11th of August, 2020

LHAP MSCP (SSD 10388) - Addendum Letter

Liverpool Hospital
Elizabeth Street, Liverpool
NSW 2170
200811 SSDA MSCP Addendum (01)

SECTION A

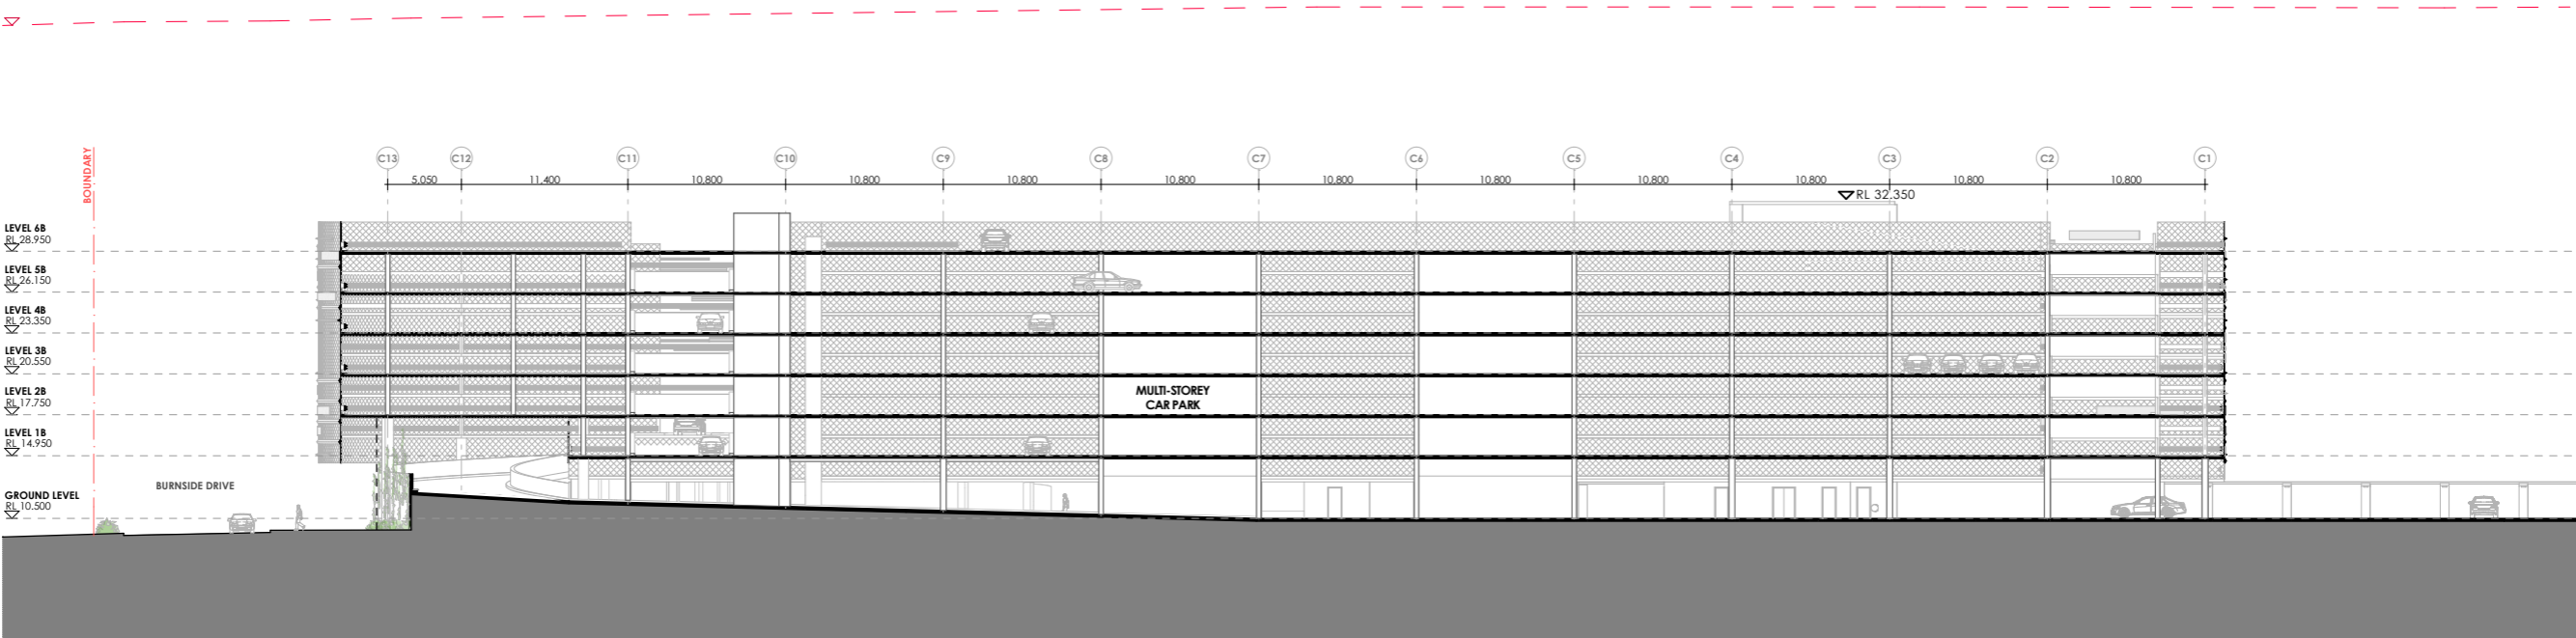
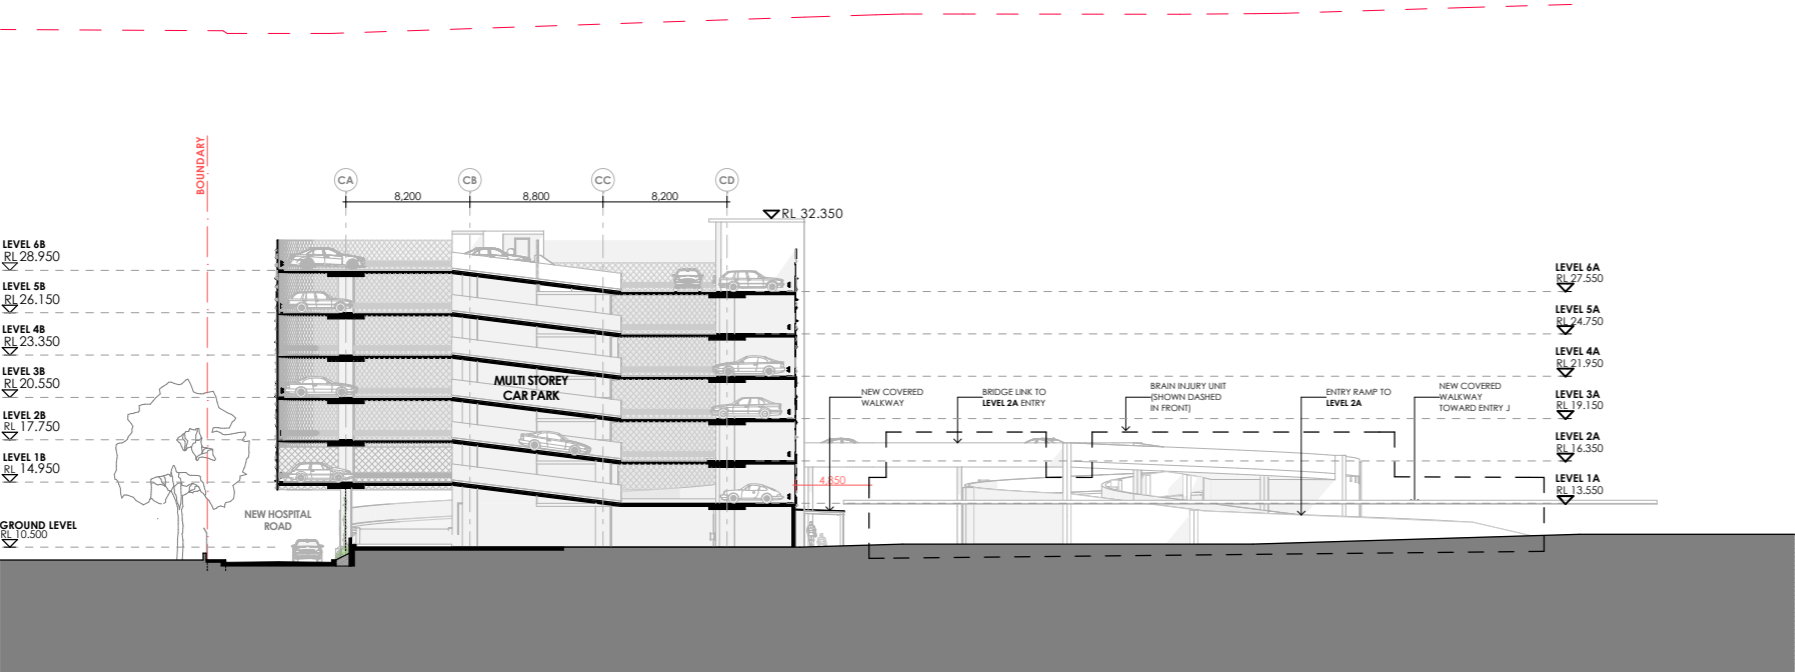
- Additional level (Level 7) added

NORTH ELEVATION

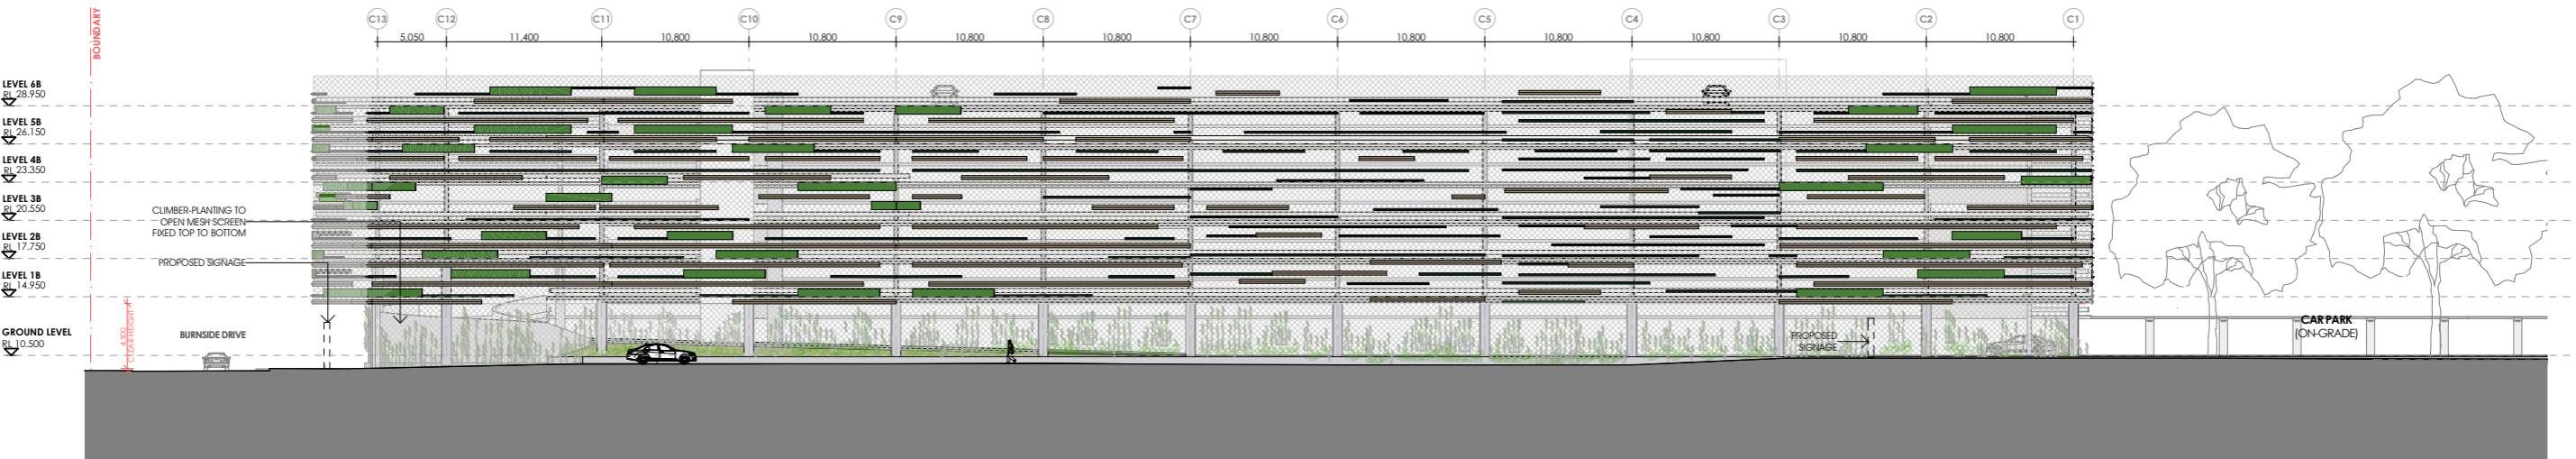
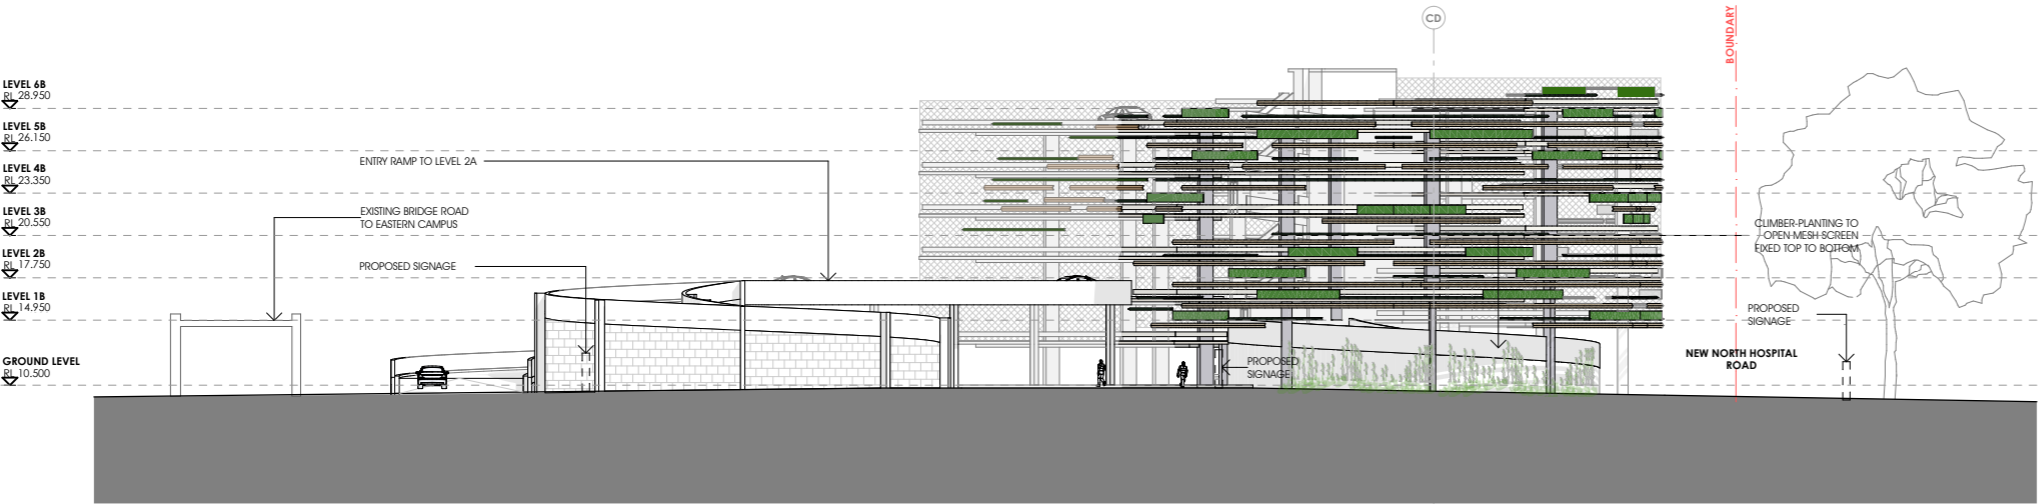
- Additional level (Level 7) added

SOUTH ELEVATION

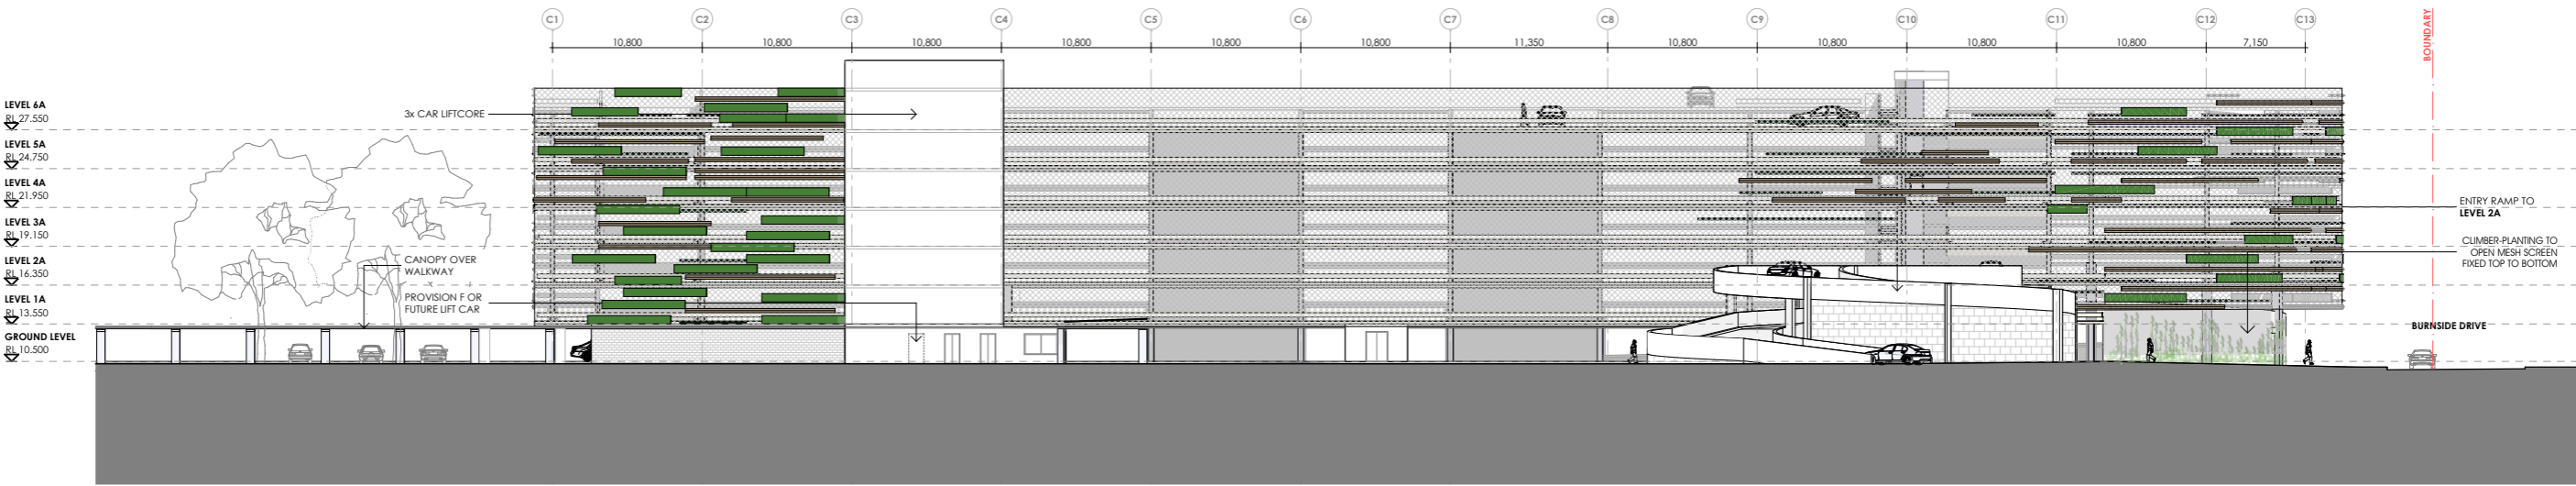
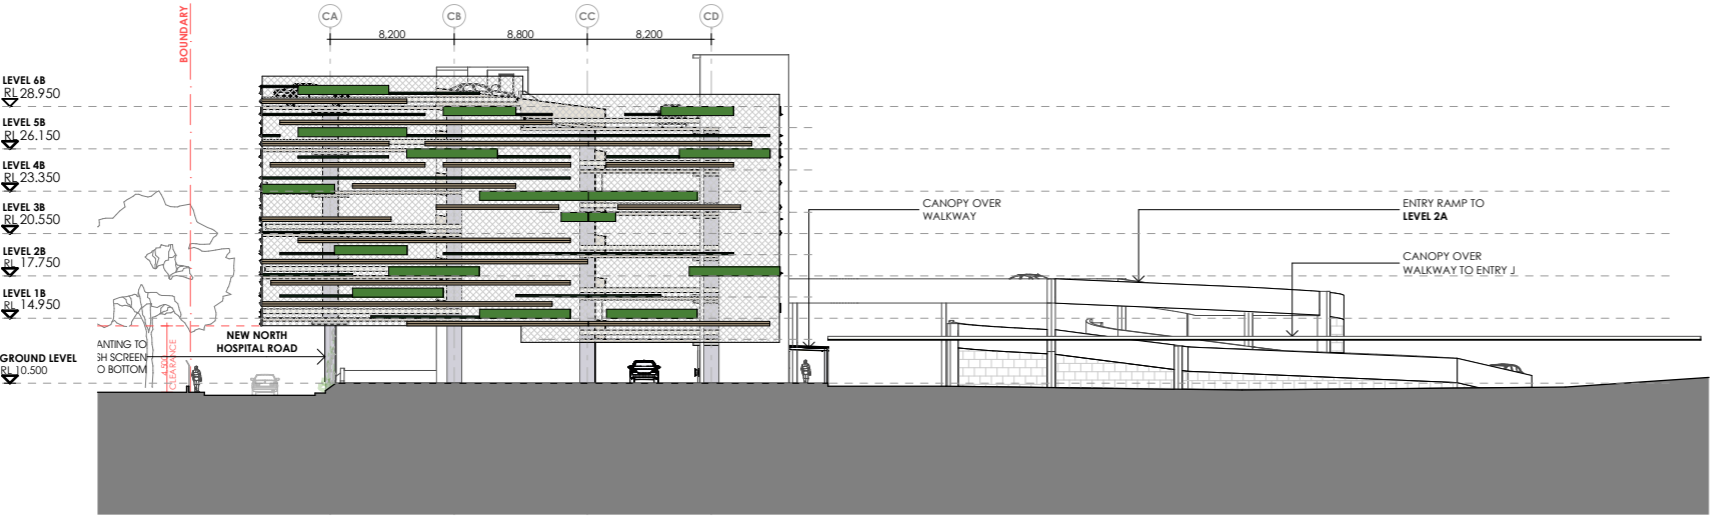
- Additional level (Level 7) added
